PLANNING AMENDMENT

Applicant: Mr A Bines
Lambley Mill Cottage
Northons Lane
Holbeach
Spalding, Lincs.
Description: Ground floor extension and garage

Amendment: Garage re-positioned
Dwg.Nos. LAM/D02-100B

**RE: - Proposed Ground Floor Extension & Garage
Lambley Mill Cottage, Northons Lane Holbeach, Spalding**

B	06.01.03	AS PER MEET WITH INTERNAL DRAINAGE BOARD ON SITE. MOVE GARAGE TO 7.5M FROM DRAIN	PDD	
A	13.12.02	SUBMIT TO L.A.	PDD	
REV	DATE	DESCRIPTION	INIT	
REVISIONS

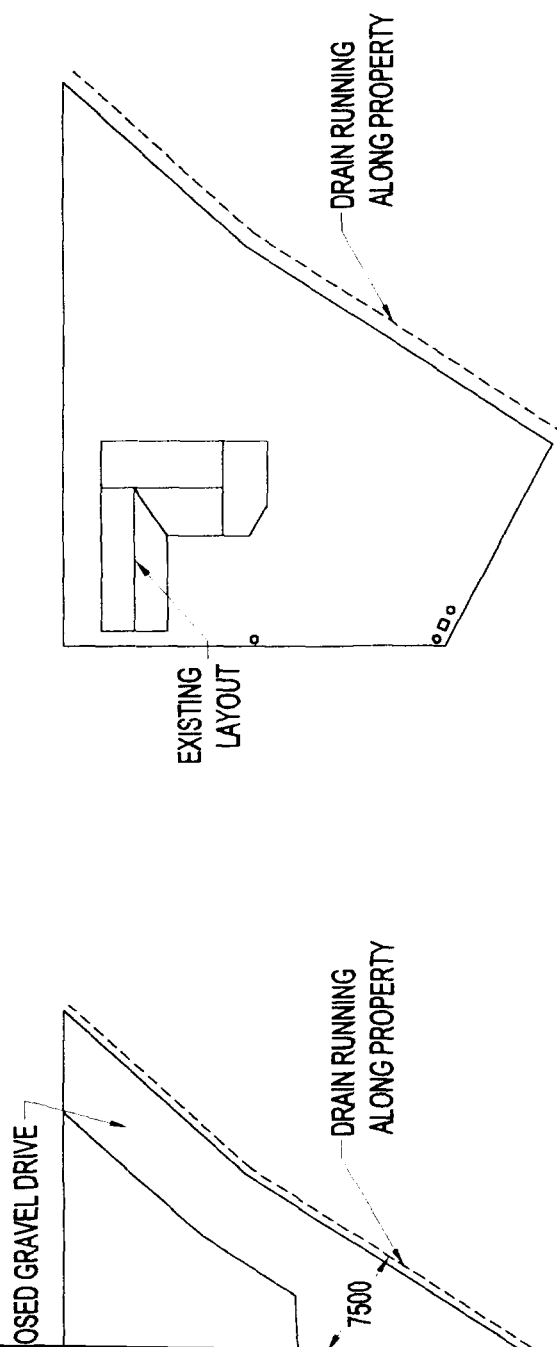
Please find enclosed a revised site plan for the above property, for which there has been an application for planning permission for a ground floor extension and detached garage (Drg's LAM-D02-100 rev 'B').

As per our discussions at the site meeting 03.01.03, the garage has been moved to 7.5 metres from the centre of the drain to allow for any access to the drain if required.

A compacted gravel driveway has been proposed to allow for any future work that might be needed.

The permission is required from the Internal Drainage Board due the garage being 7.5 metres from the drain, thus requiring a relaxation in the bylaws, which states 9 metres.
